Application No: LU/151/21/PL
Site Address: 25 River Road Littlehampton BN17 5BZ
Description of works: Demolition of existing car garage and the erection of 2 no. two-storey residential buildings comprising 5 no. flats with associated works. This site affects the character & appearance of the Littlehampton River Road Conservation Area & is in CIL Zone 4 (Zero Rated) as flats.

Thank you for your internet representation made on 15th June 2021 which has been recorded as an objection with the comments as follows:

OWPC37446

TA 1235 / 12

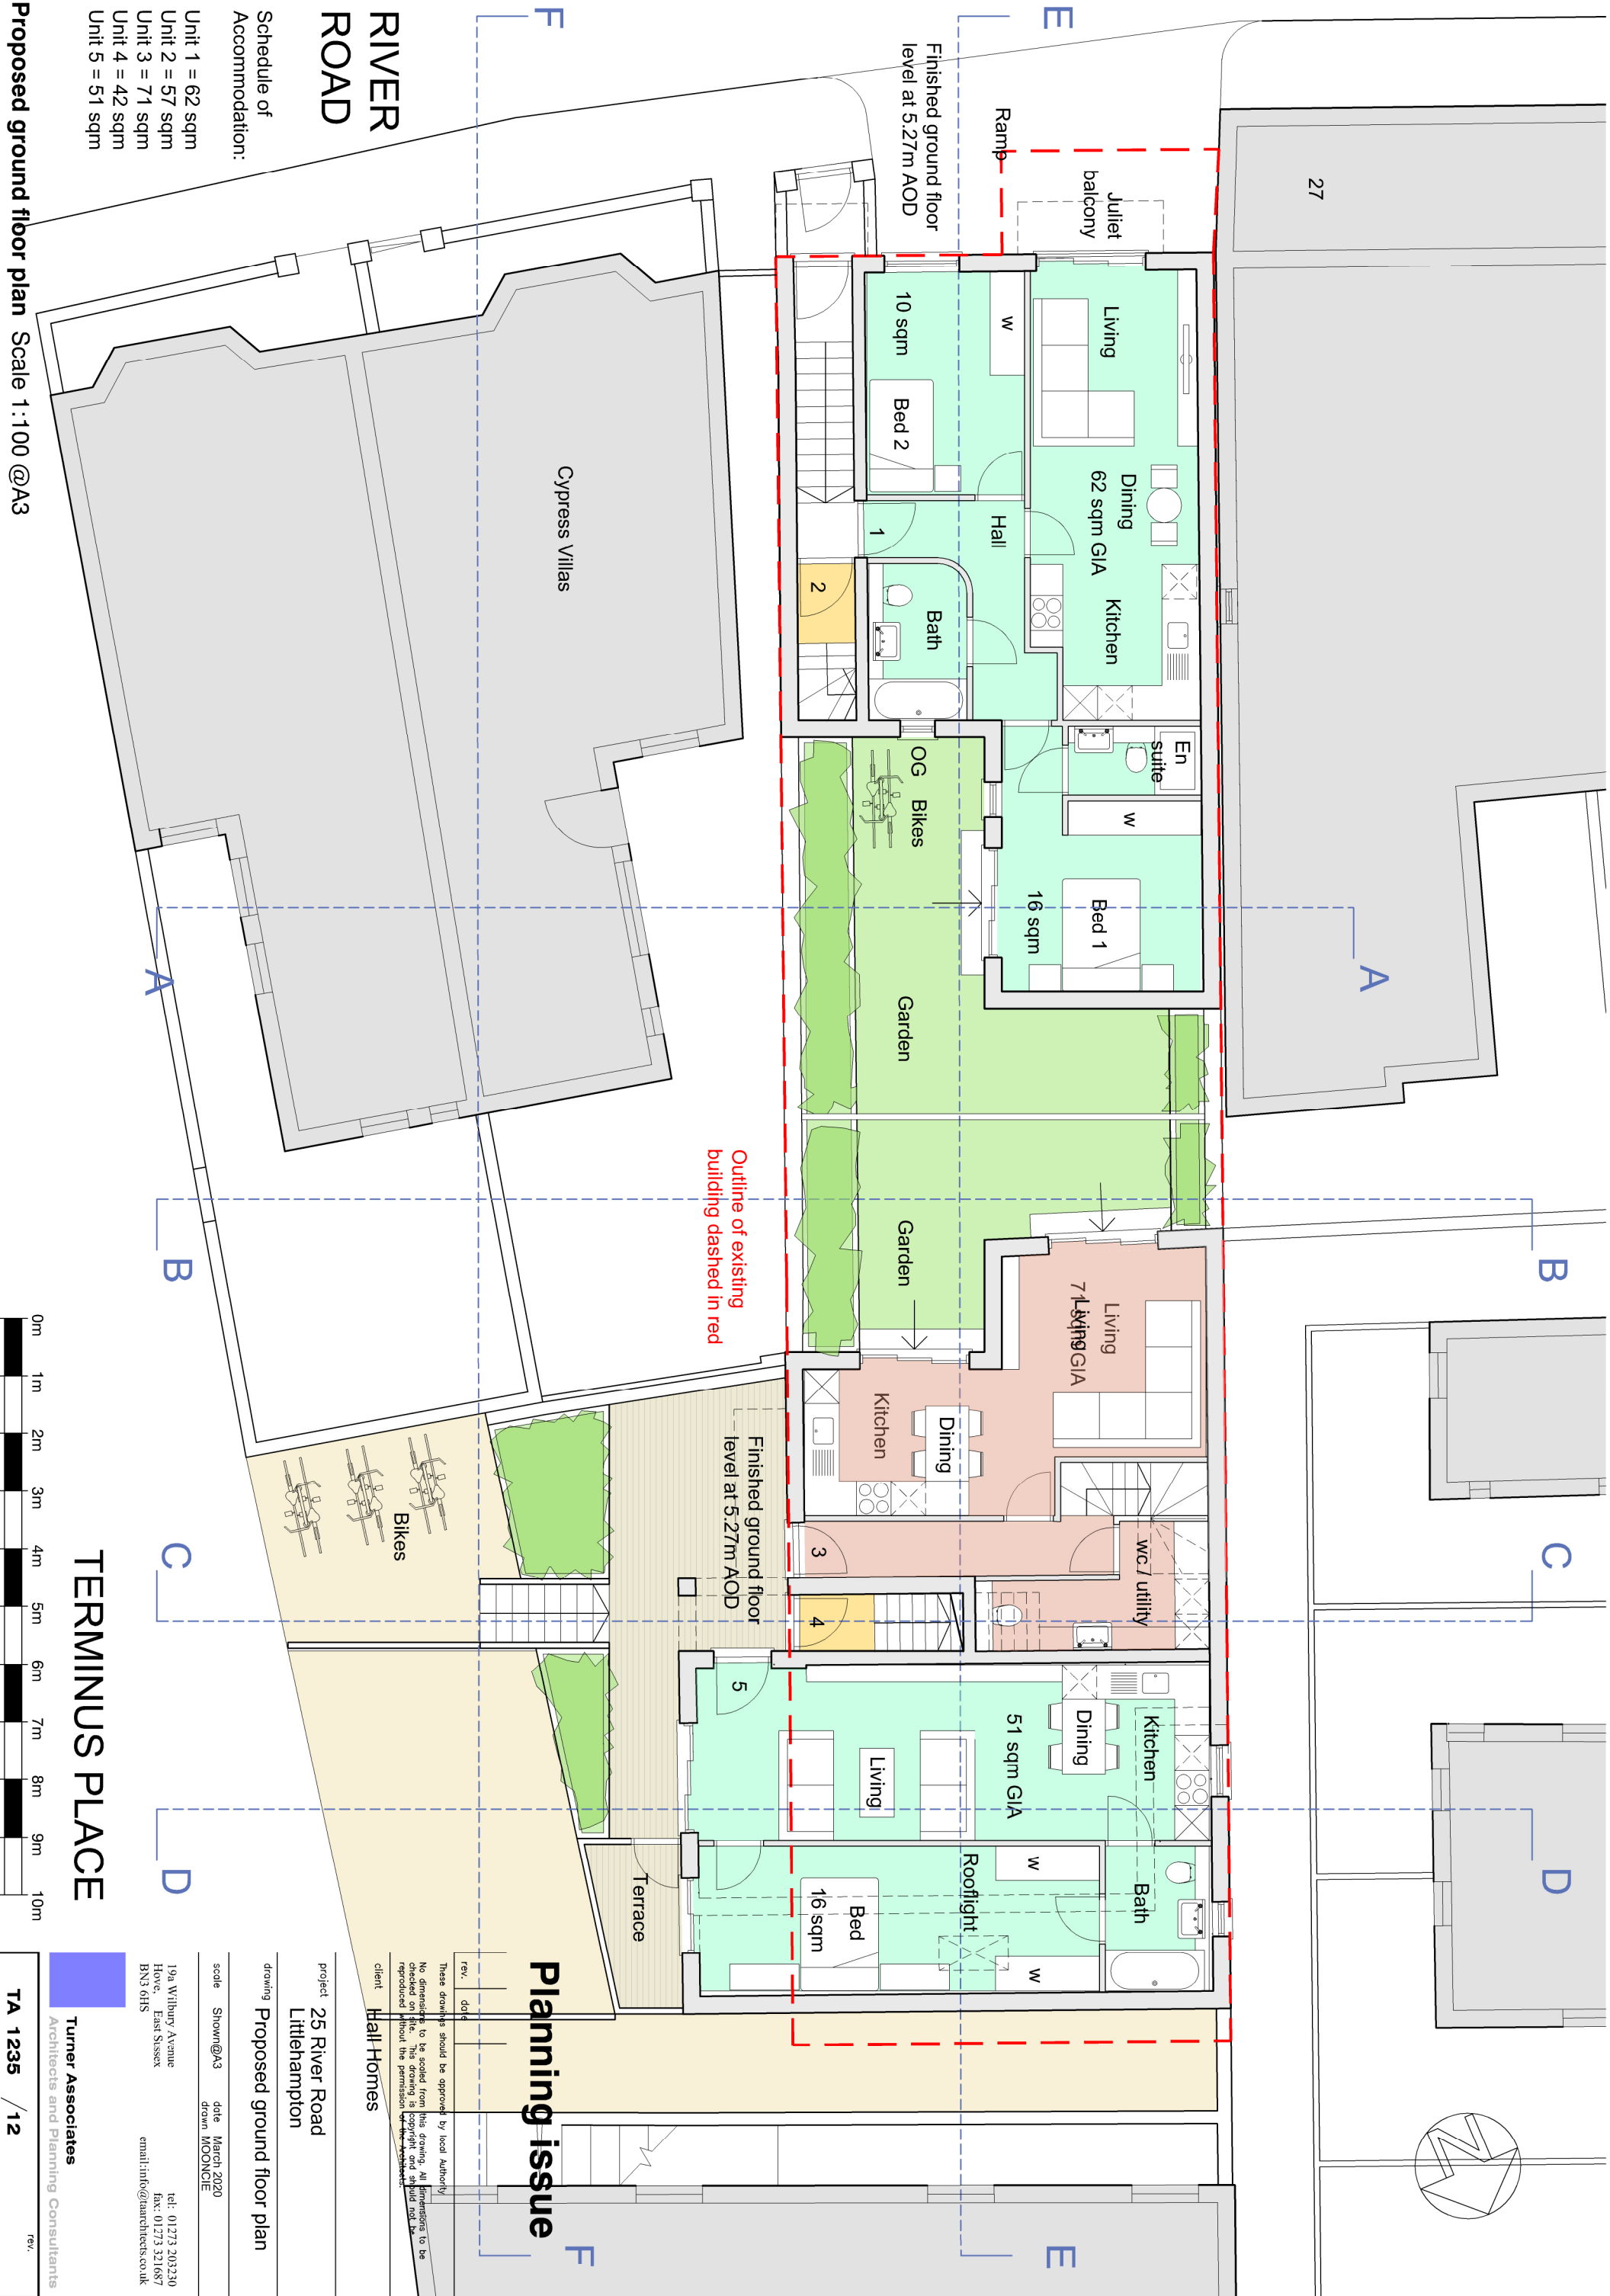
5. TA 1235 / 16 and TA 1235 / 12 and TA 1235 / 19 - will there be screening to the wall to ensure anyone using the area is not able to:

A - Object to block in Terminus Place due to height and detriment to other dwellings

B - gain access to our garden due to the increased ground height

C - look into the garden whilst accessing the raised area to their front door flats 3, 4, 5.?

D - Extend the party wall to encompass 1 River Road Garden and screen all along

TA 1235 / 10

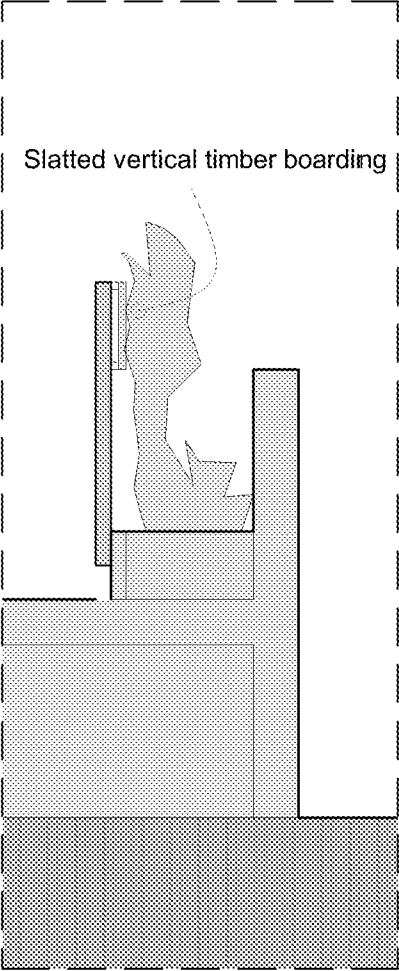
6. TA 1235 /10 -TA 1235 / 15 and TA 1235 / 13 and TA 1235 /23- Green Roof space -

A - What access is being provided to this space

B - Whilst it is set back from the joining wall - will they be able to look into our garden?
